Addendum No. 1

RE: Contract # C204521

Pitt County (BR-0119)

BRIDGE #109 OVER GRINDLE CREEK ON SR-1514 (STATON MILL RD).

| PROJECT REFERENCE NO.<br><b>BR-0119</b>   | SHEET NO.<br><b>4</b>   |

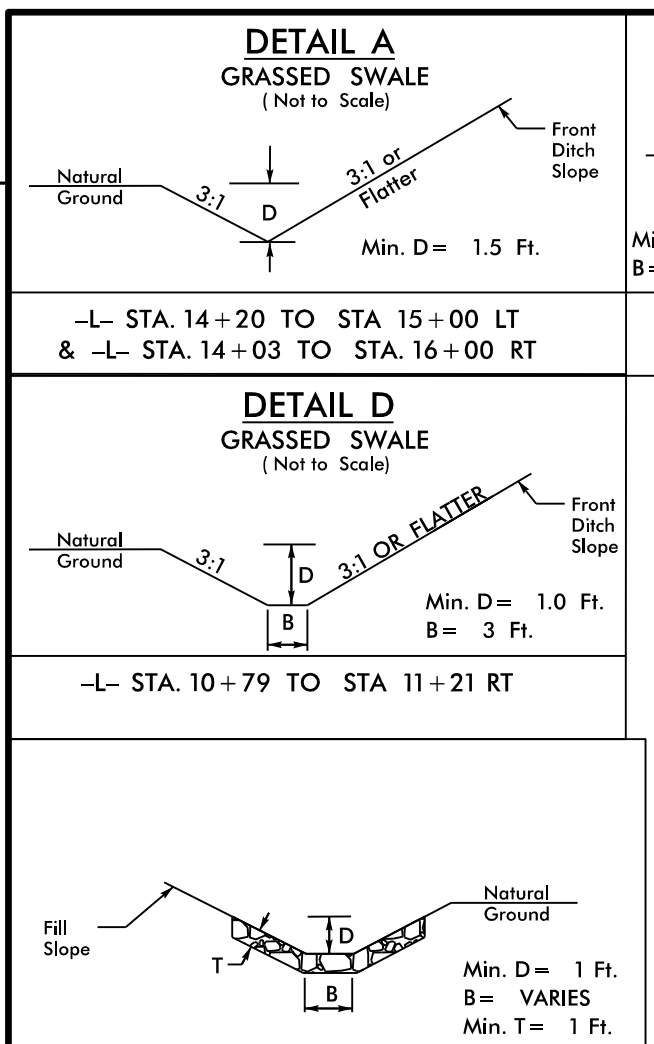
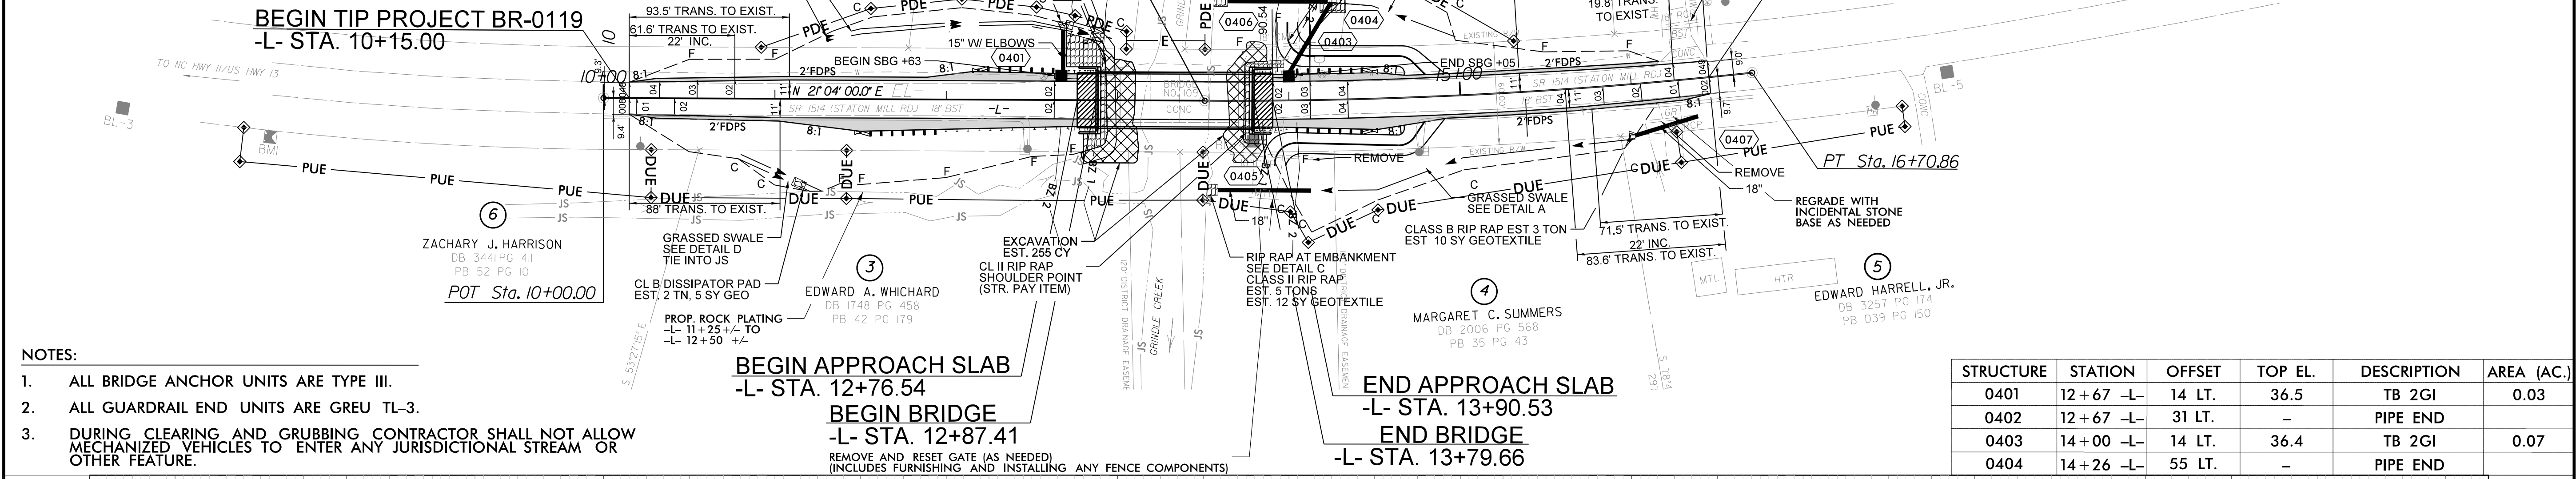
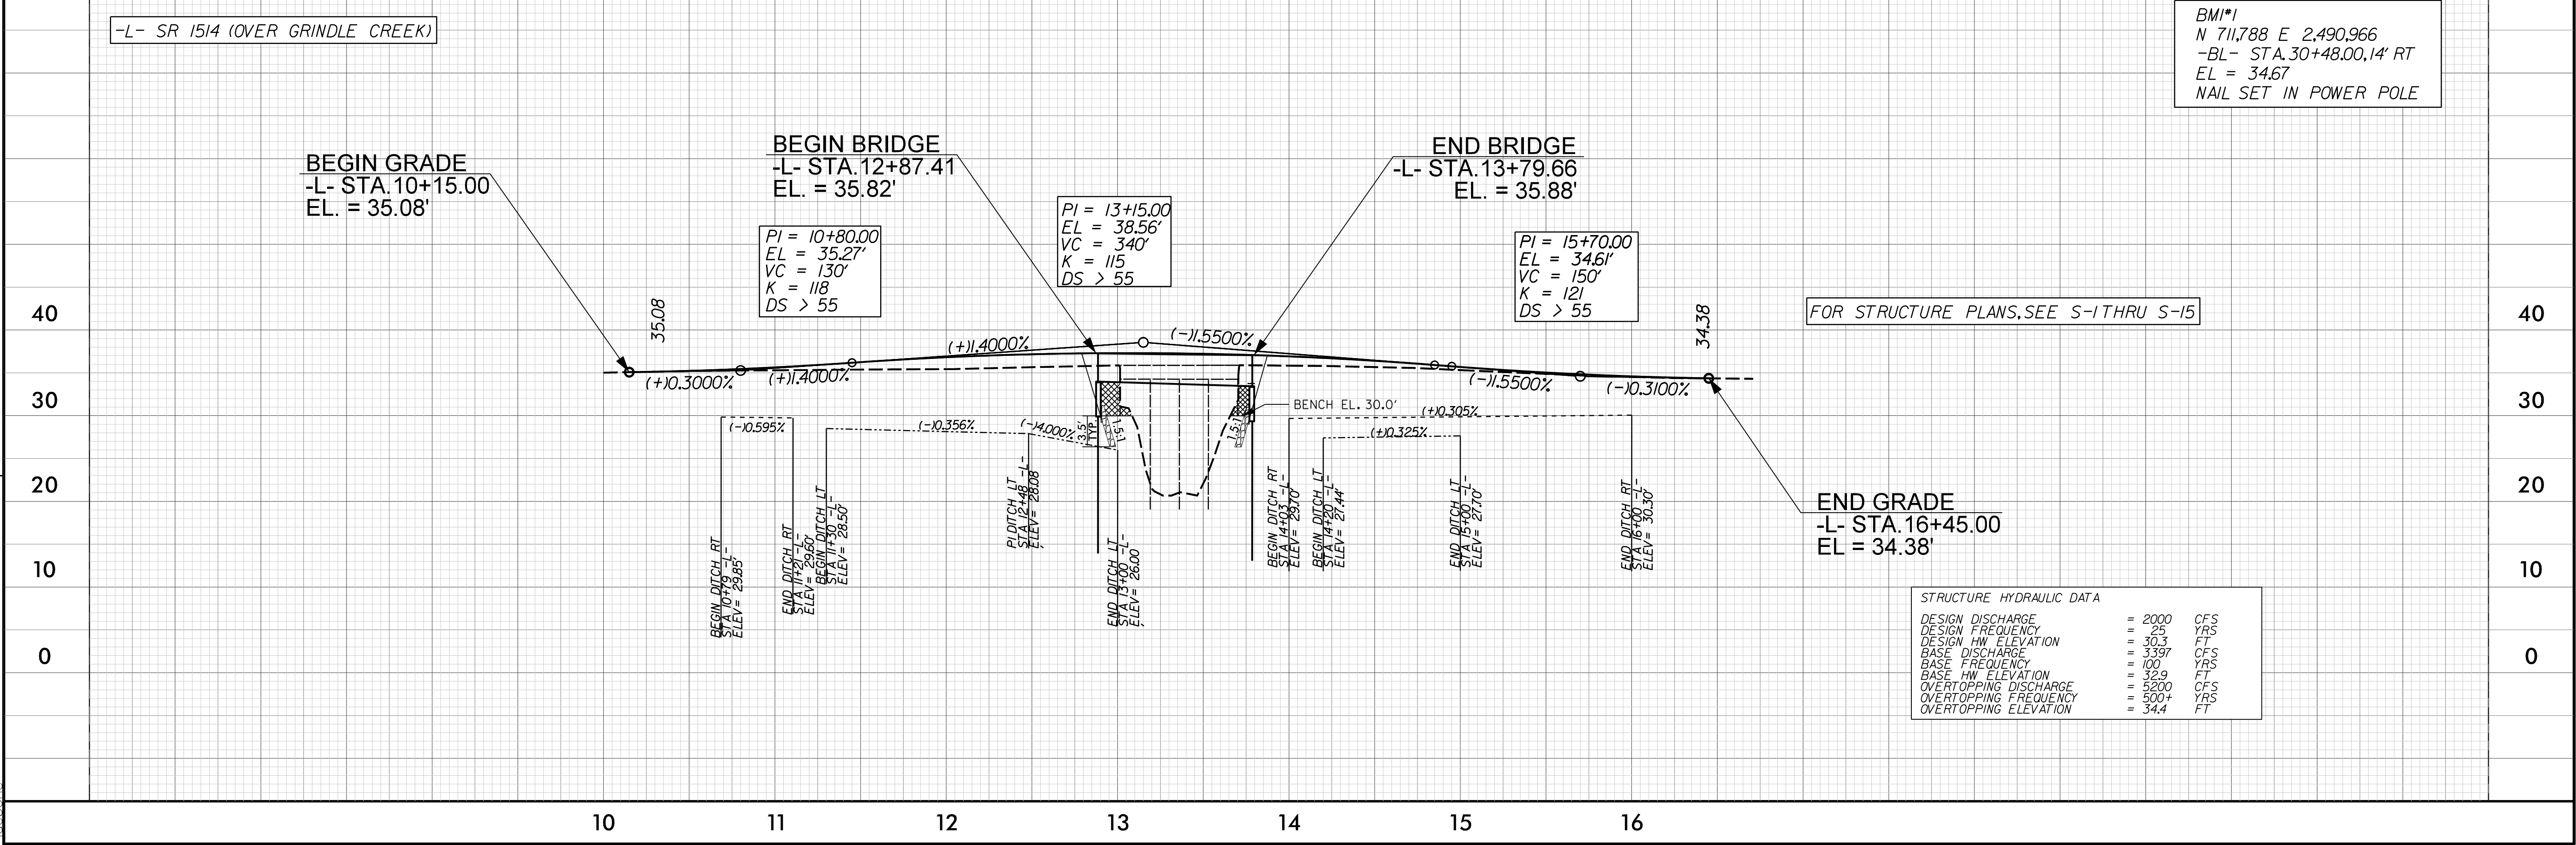
Sheet Nos.	Revision
4 & 4A	PUE & DUE point locations on the Right (east) side of the road shifted slightly in space so that all points land at whole number stations and offsets as called out on sheet.
